15 March 2024

**SECTION 73 APPLICATION TO VARY CONDITION 1 RELATED TO APPROVED DRAWINGS TO PLANNING CONSENT 23/00863/FUL.
AT BOB'S FARM, VYNE ROAD, SHERBORNE ST JOHN, HAMPSHIRE, RG24 9HX.
FOR THE ERECTION OF 9 DWELLINGS AND ASSOCIATED LANDSCAPING, ACCESS AND CAR PARKING FOLLOWING THE DEMOLITION OF EXISTING AGRICULTURAL AND B8, STORAGE AND DISTRIBUTION USE BUILDINGS AND HARDSTANDING.**

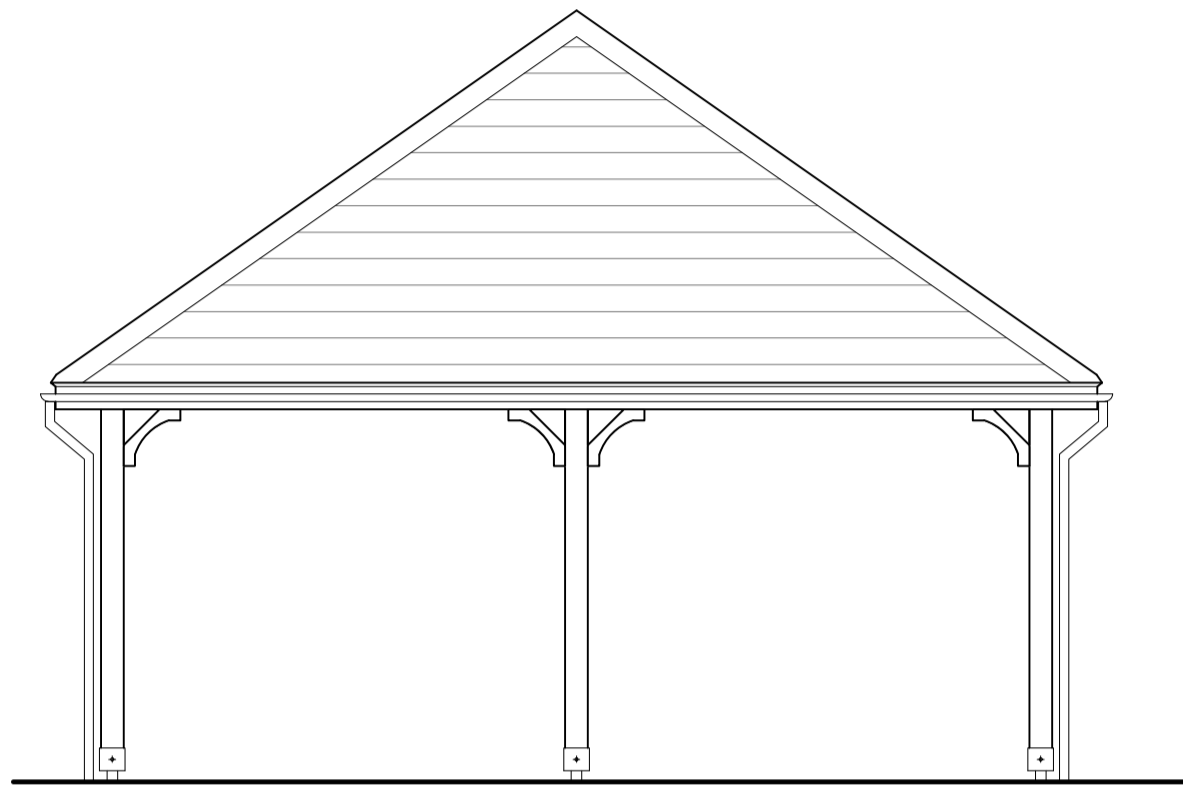
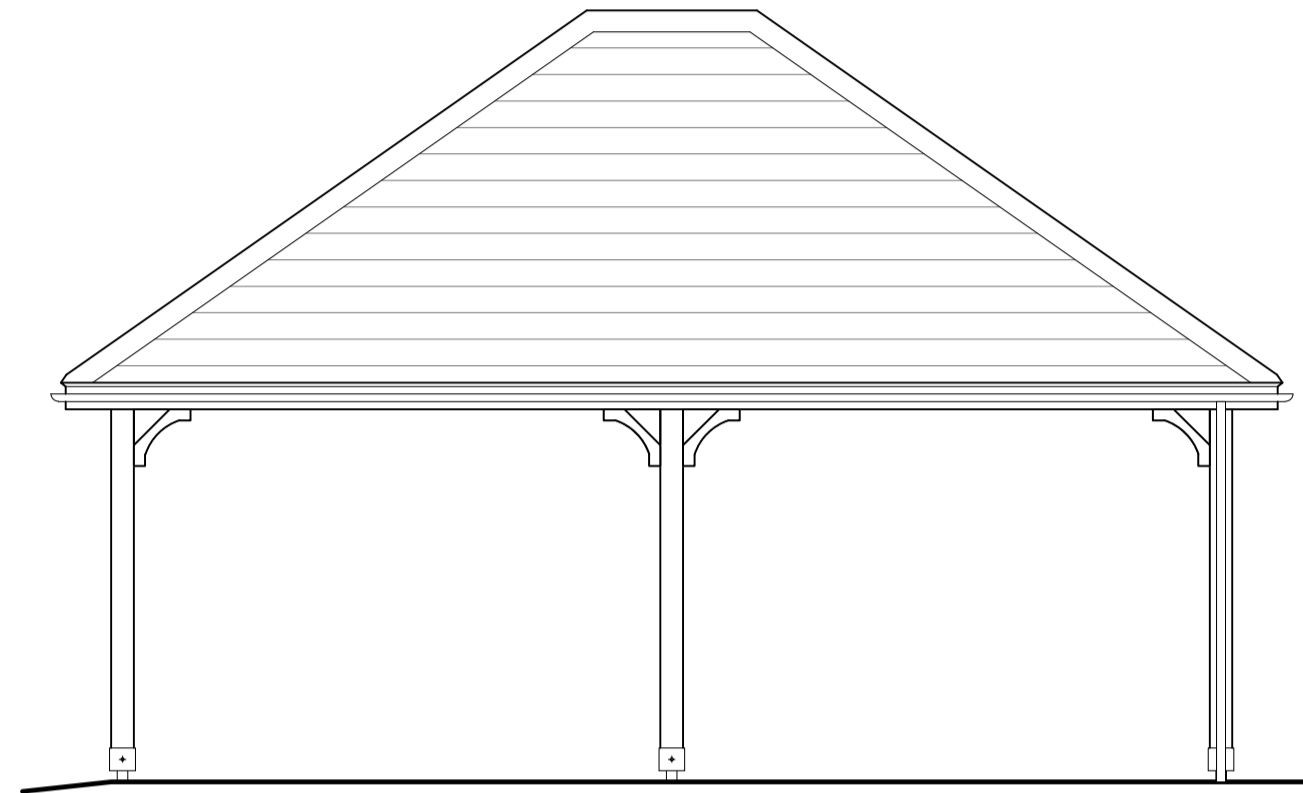
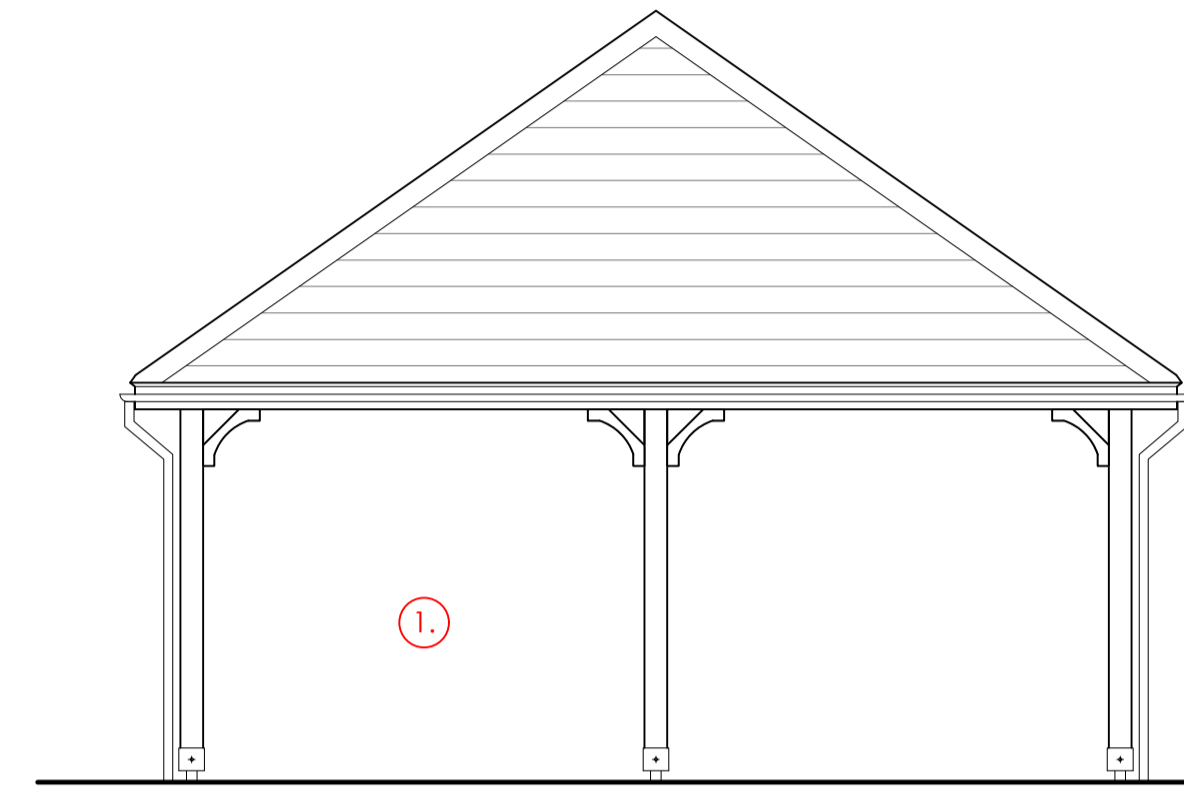
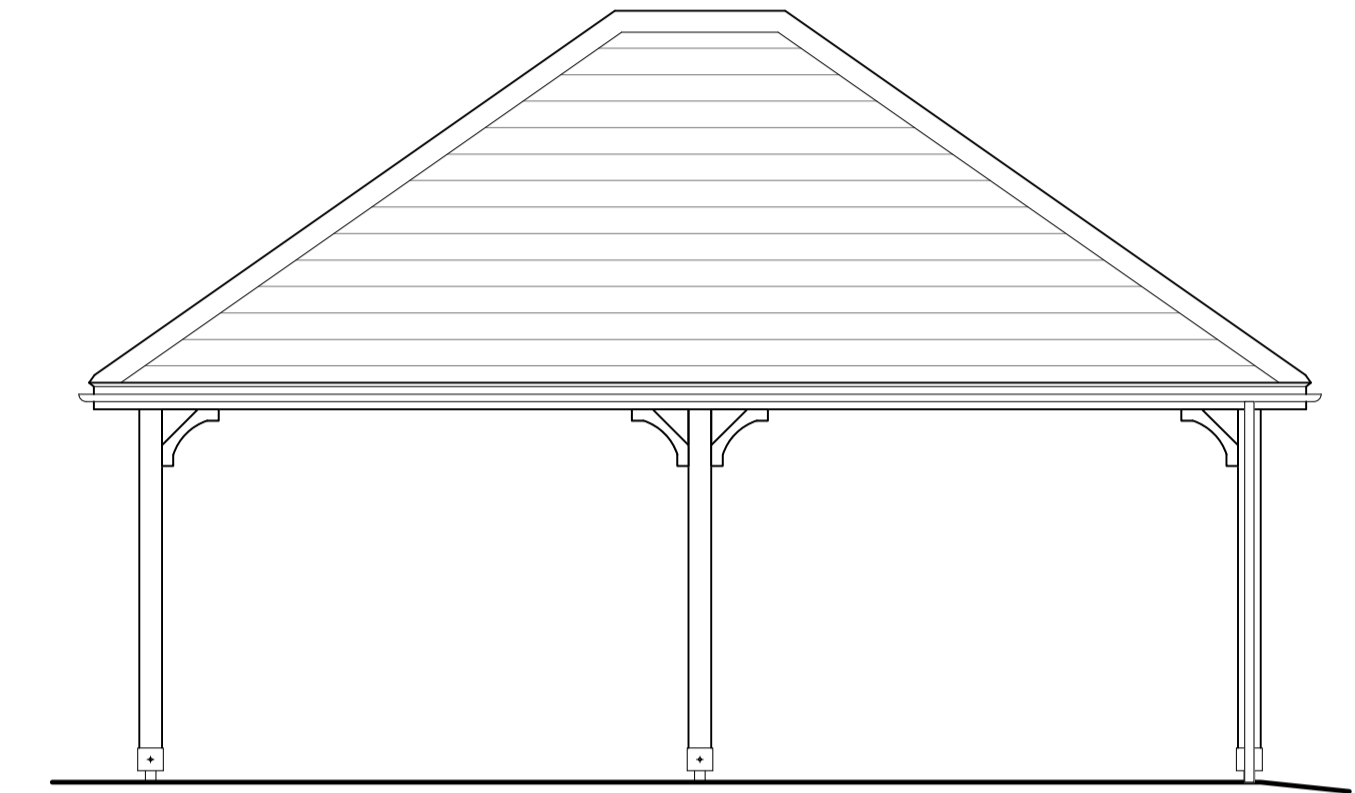
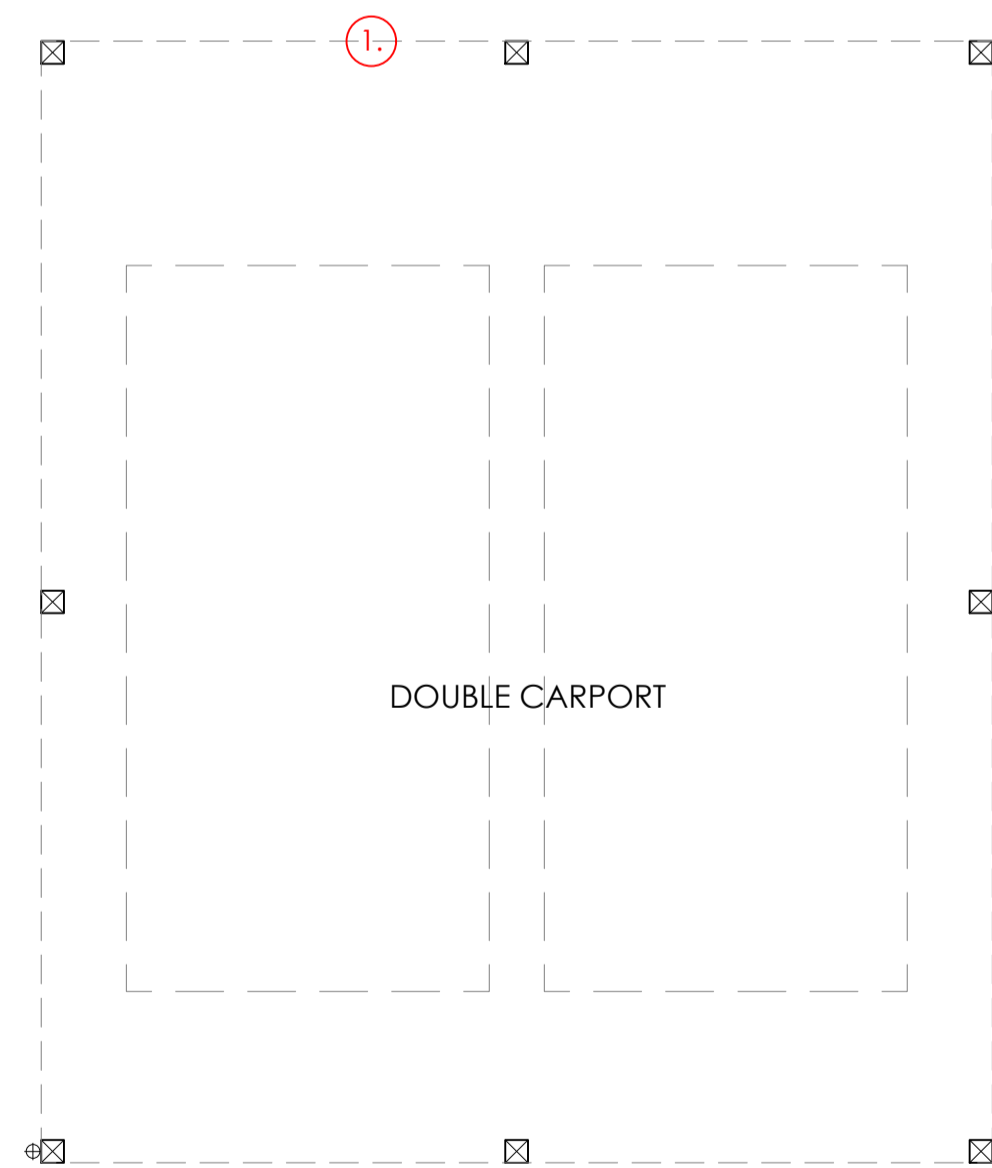
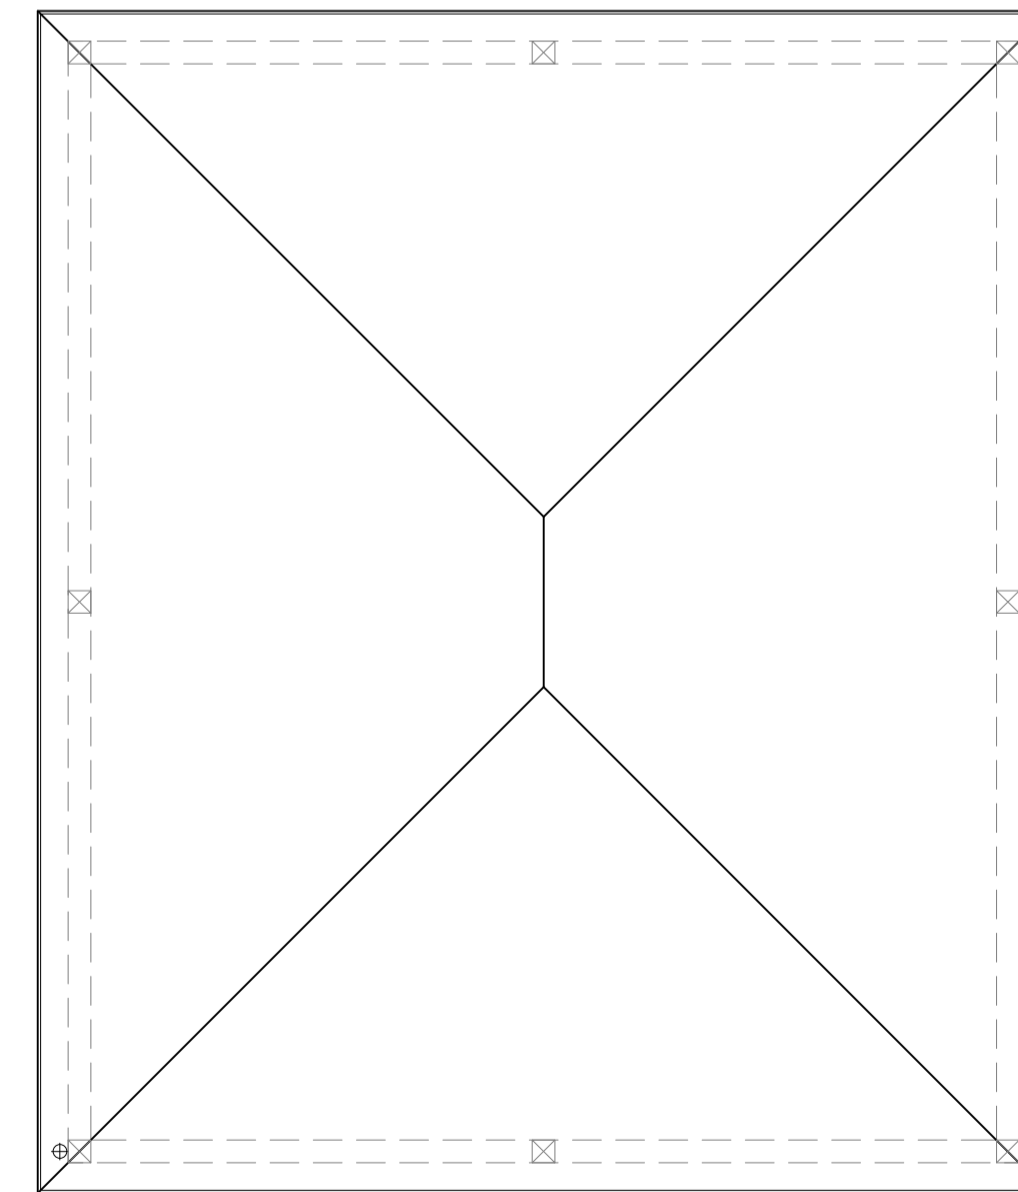
- Site Plan – addition of air source heat pumps to all houses; 2no. double garages replaced with double carports (no walls); 2no. double garages replaced with single garages (*nb. Garage changes were approved by NMA decision but updated to now remove the single wall to the carports*)

JOB NO. 8160 DRAWING NO. D12 REV B

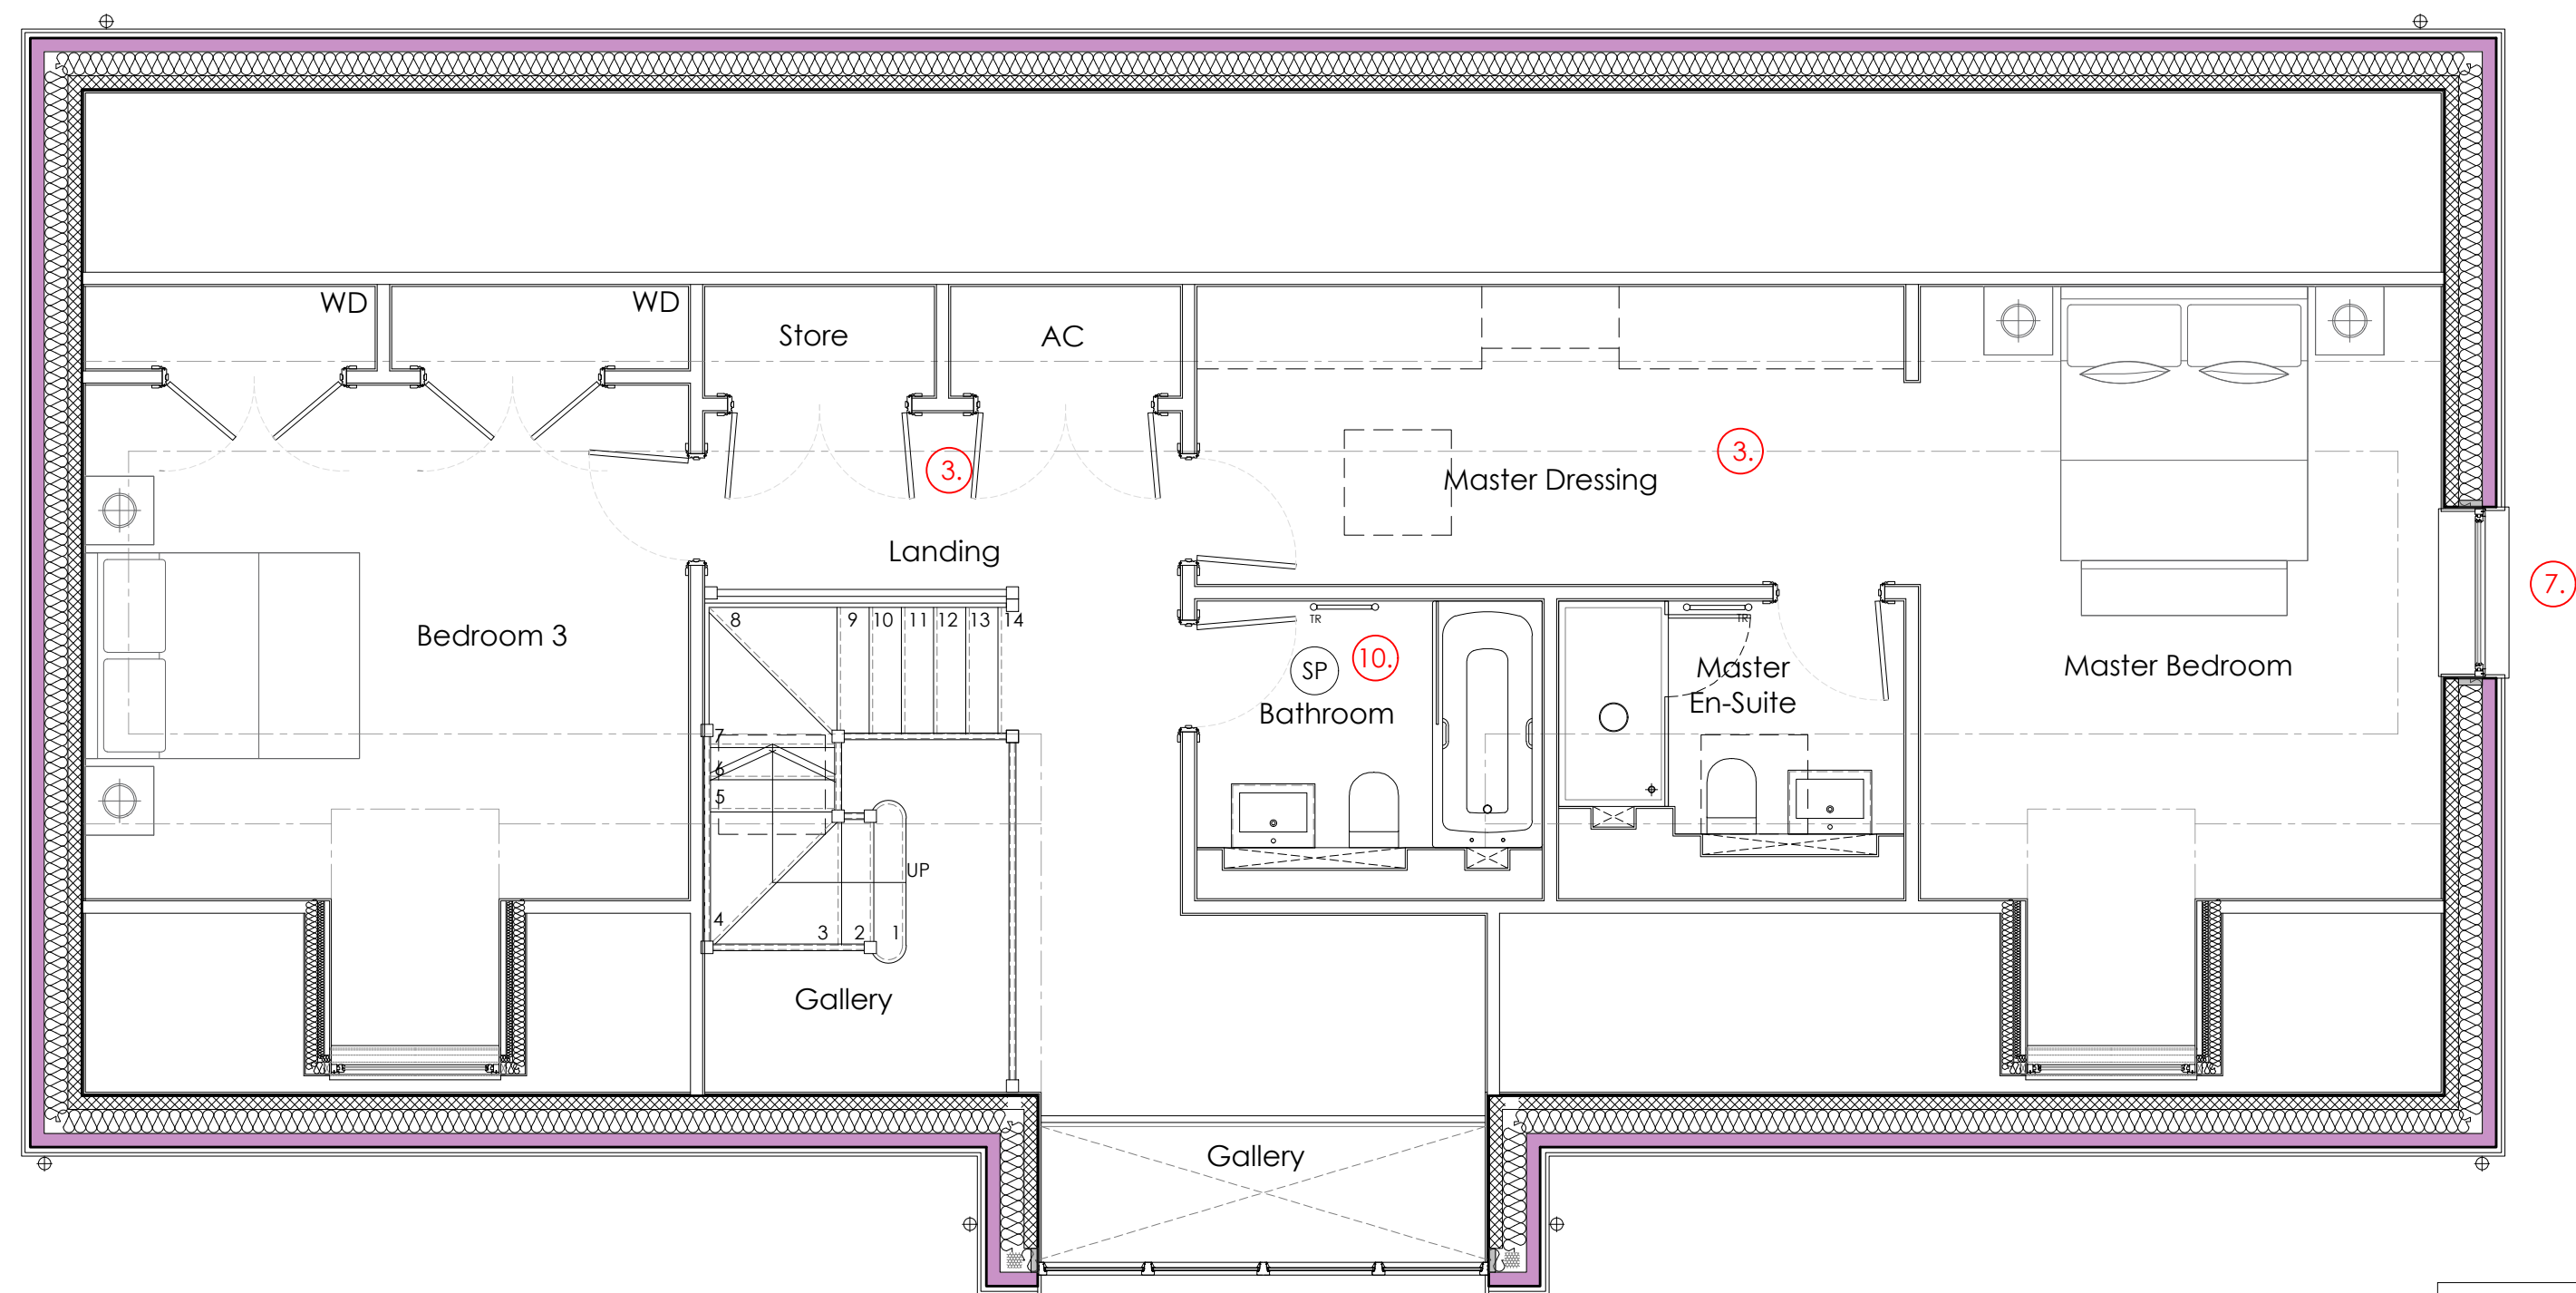
- Plot 4 – fenestration changes; and remove one chimney.
- Plot 5 – fenestration changes including removal of windows and rooflights, and add sunpipe; and remove flue.
